Listed building consent for a single storey rear extension, new timber boarding & fenestration changes, formation of internal walls to create additional living accommodation & alterations to existing window openings & replace with Crittal windows on NE & NW ground & first floor.

30 High Street Arundel

Thank you for your internet representation made on 8th October 2019 which has been recorded as '**no objection**' with the comments as follows:

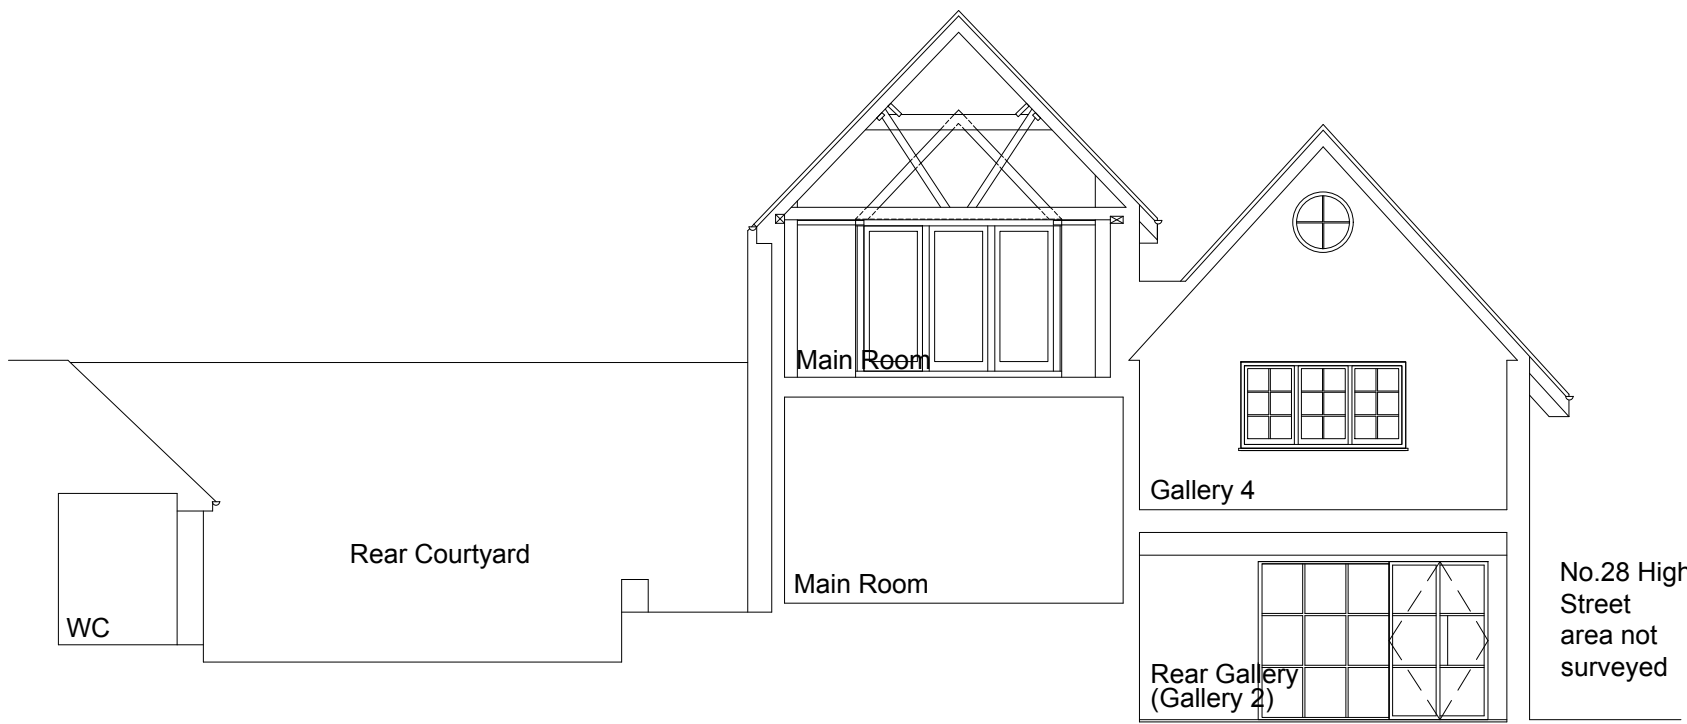
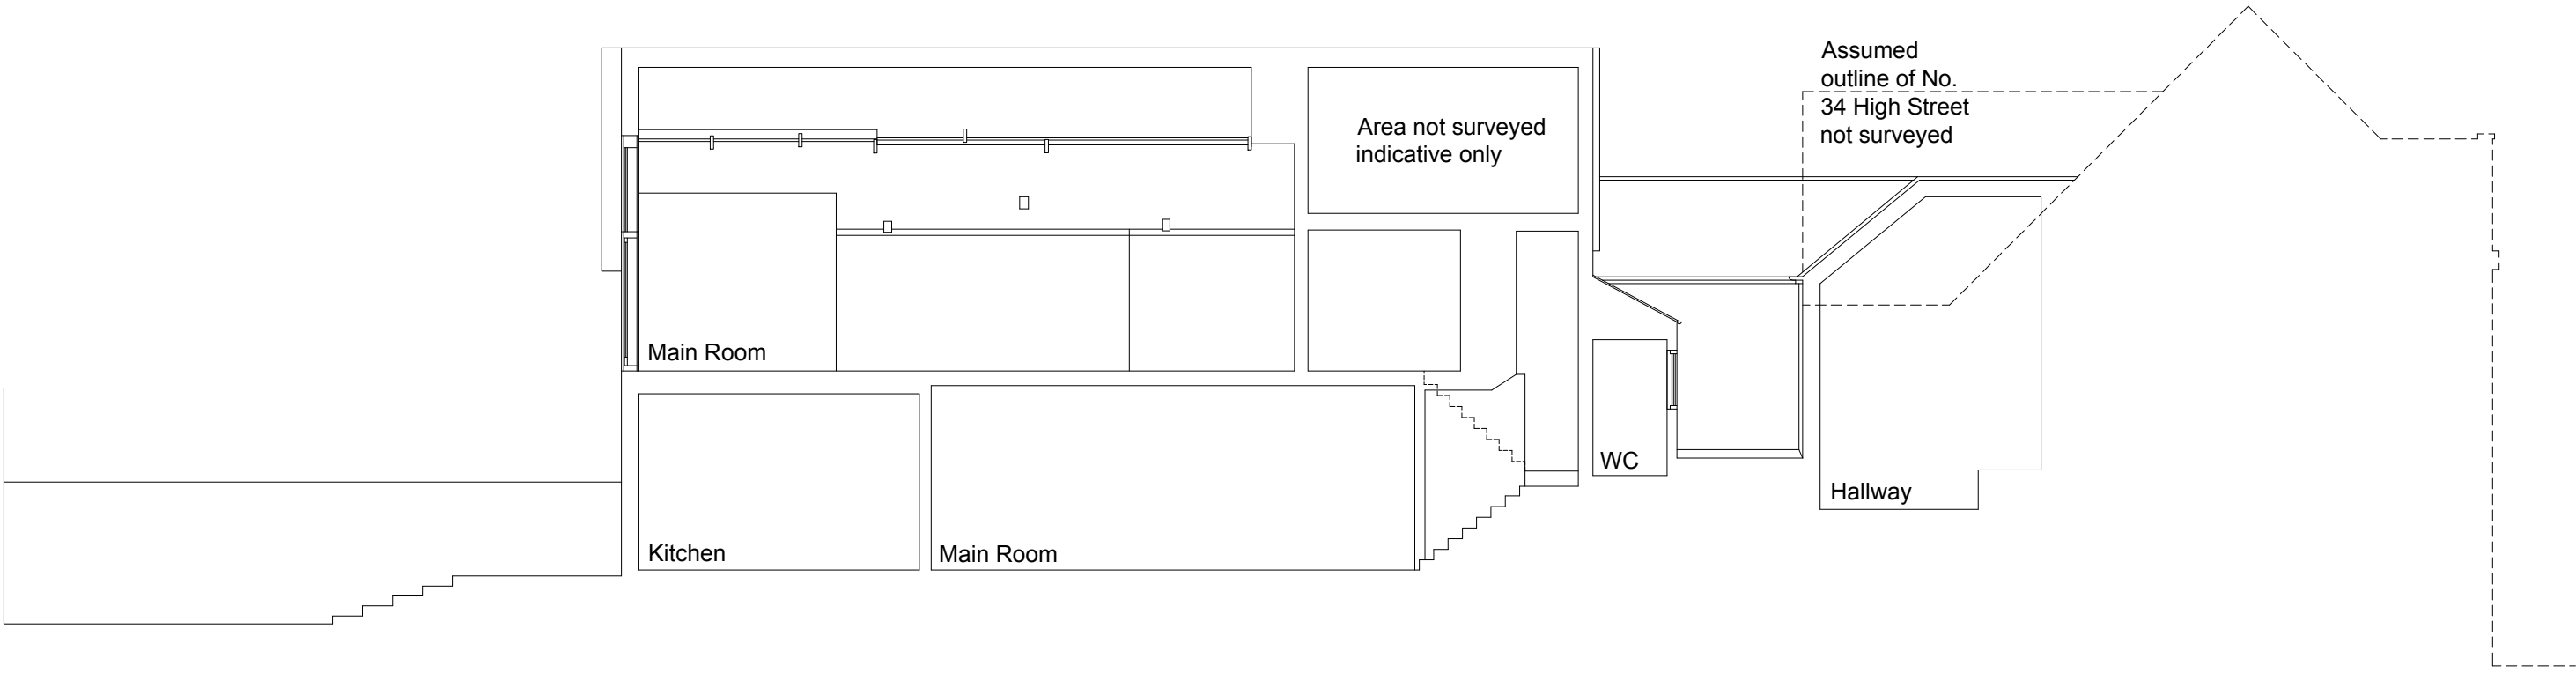
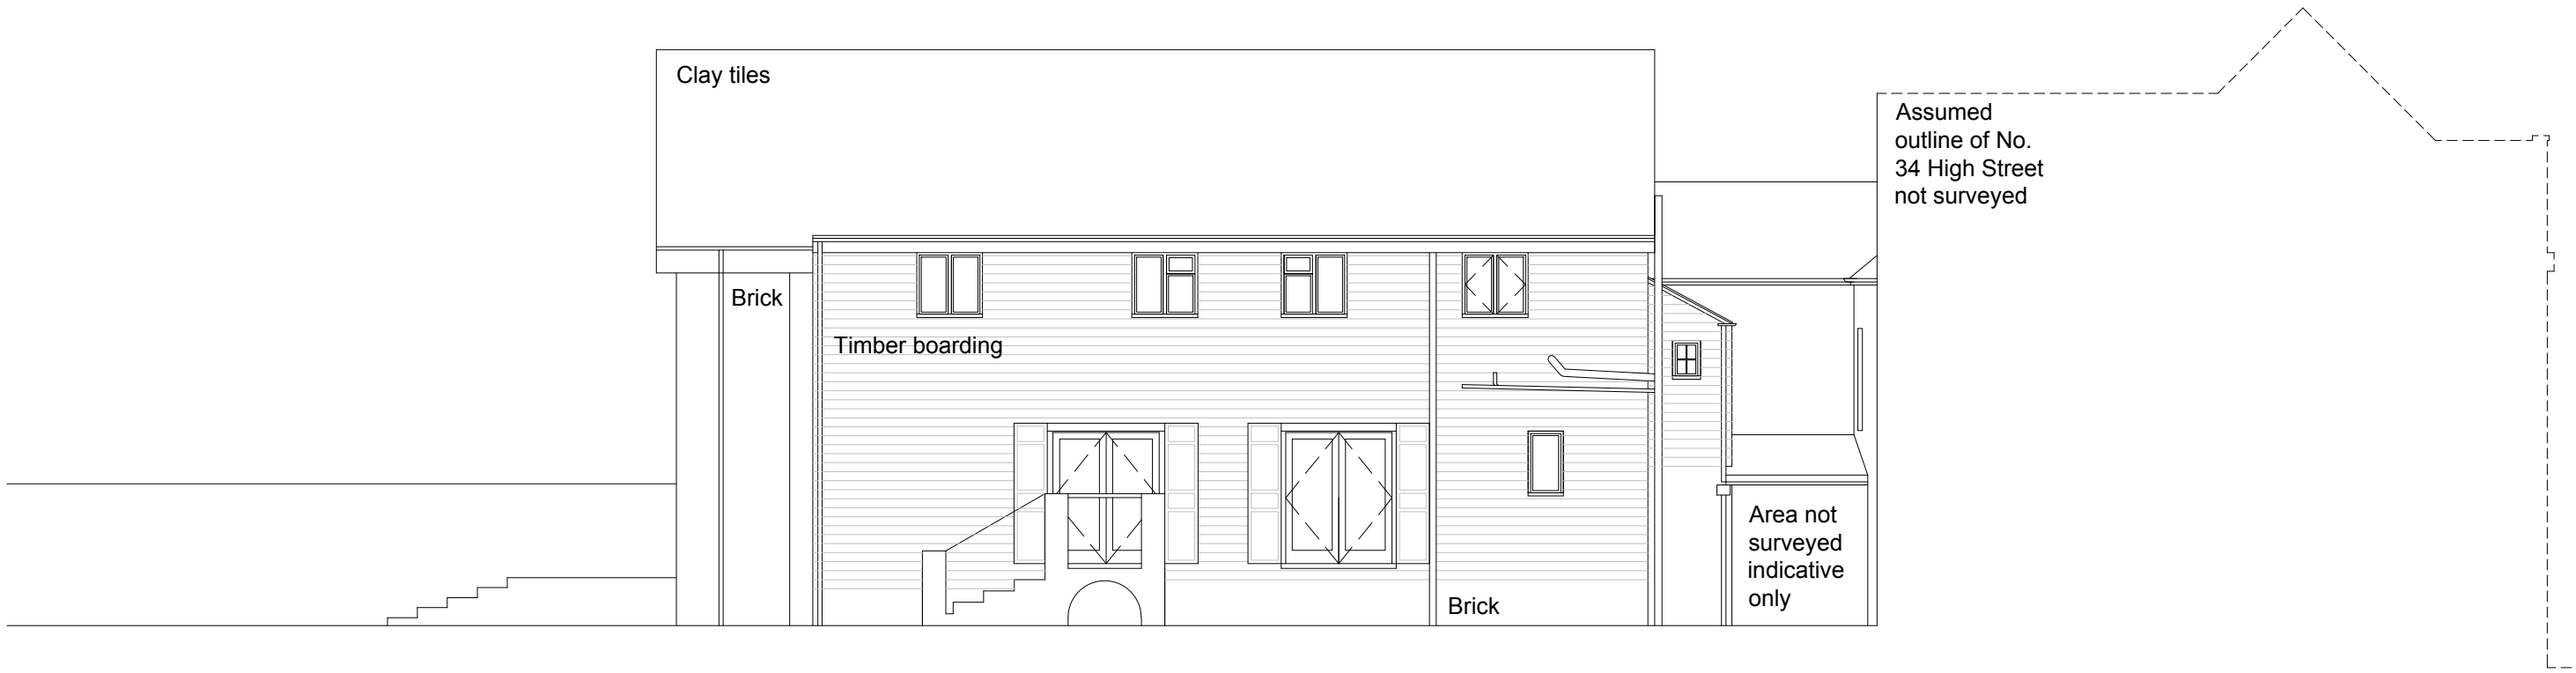
The principal changes to the existing elevations to the rear of the building appear to be located in those parts which were largely reconstructed in the early 20th Century and have little historical or architectural significance. From the submitted plans there appears to be fenestration of inappropriate design at first floor level in the north-west elevation of the existing rear extension.
